| DECISION DELEGATED TO HEAD OF PLANNING |

| Application No: | H14-0200-23                                            | Applicant: | Mr T Rogers |
| Proposal:       | Alterations, extension and widening of existing access |            |             |
| Location:       | The Old Farmhouse Money Bridge Lane Pinchbeck          |            |             |

SITE PLAN - PROPOSED 1:250

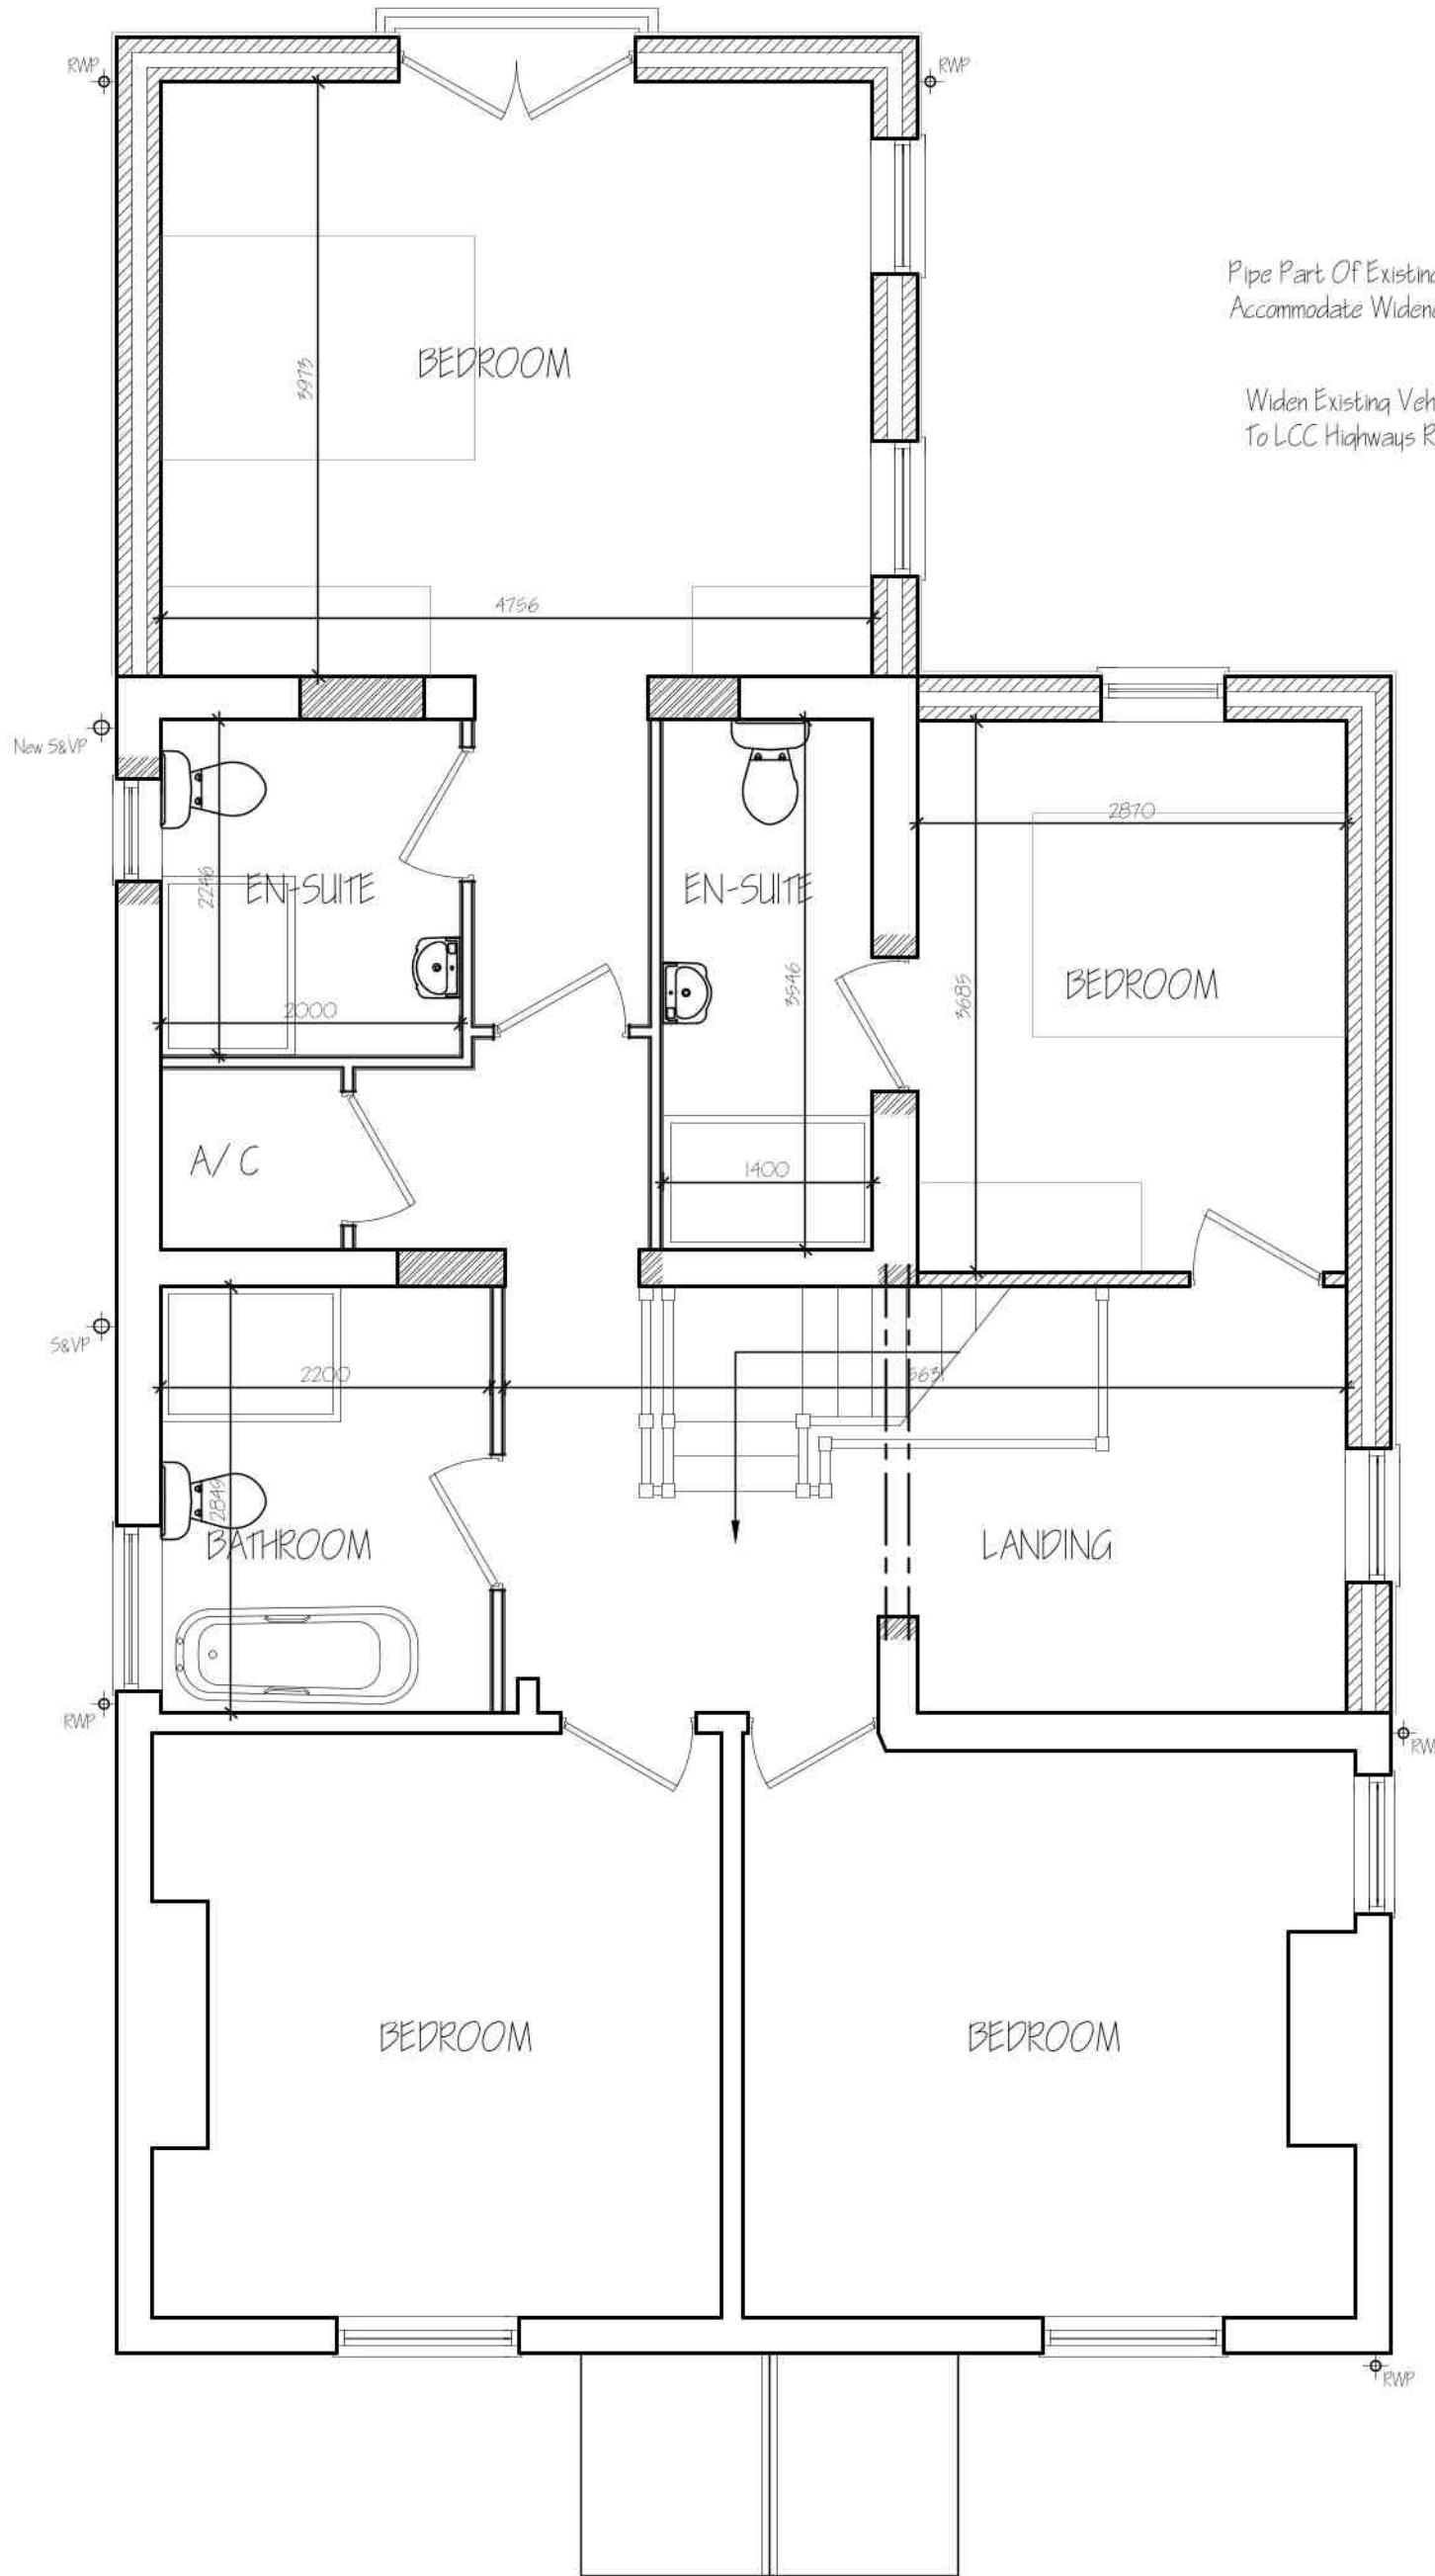
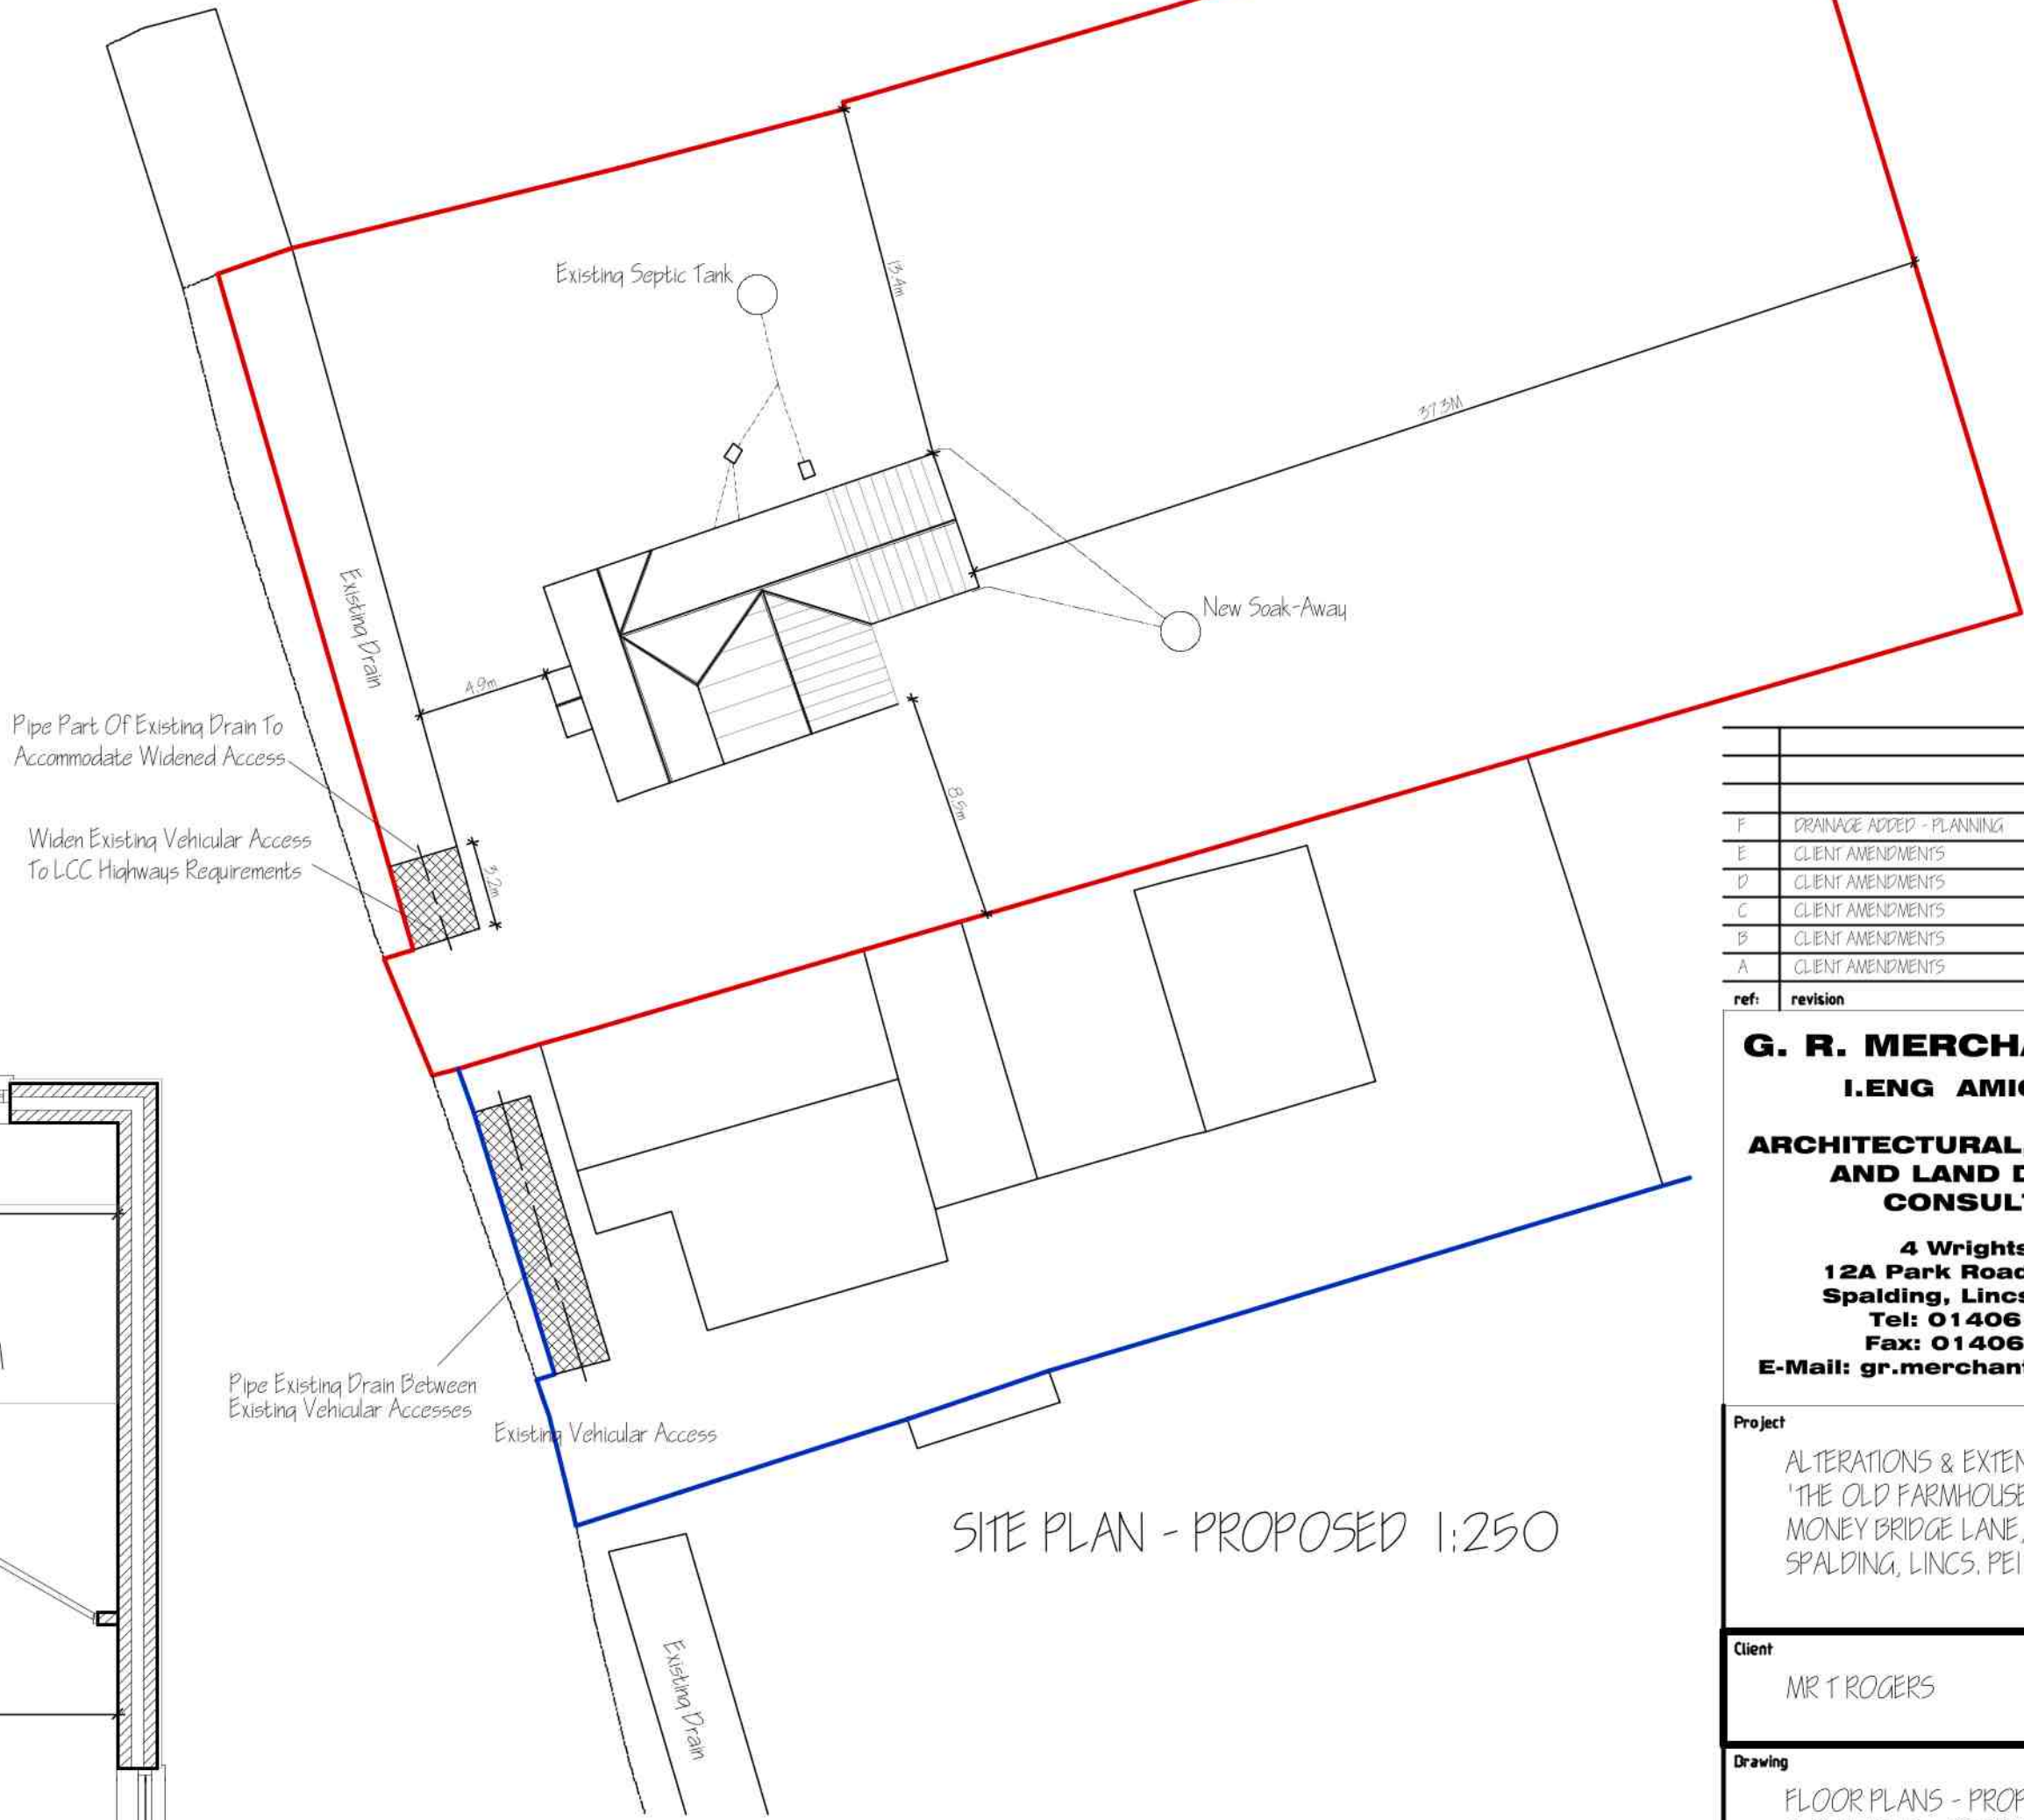
It is understood that the applicant intends to discharge surface water via soakaways. If this is the case, then any soakaways or infiltration systems should be designed and proved in accordance with BRE Digest 365 or other approved code. Evidence that soakaways are suitable for the site should be submitted to the local planning authority for their approval.

It is understood that the applicant intends to dispose of foul water to a septic tank. If this is the case, then any overflow discharge should be to a soakaway only, which should be designed and proved in accordance with BRE Digest 365 or other approved code. Evidence that soakaways are suitable should be submitted to the local planning authority for their approval.
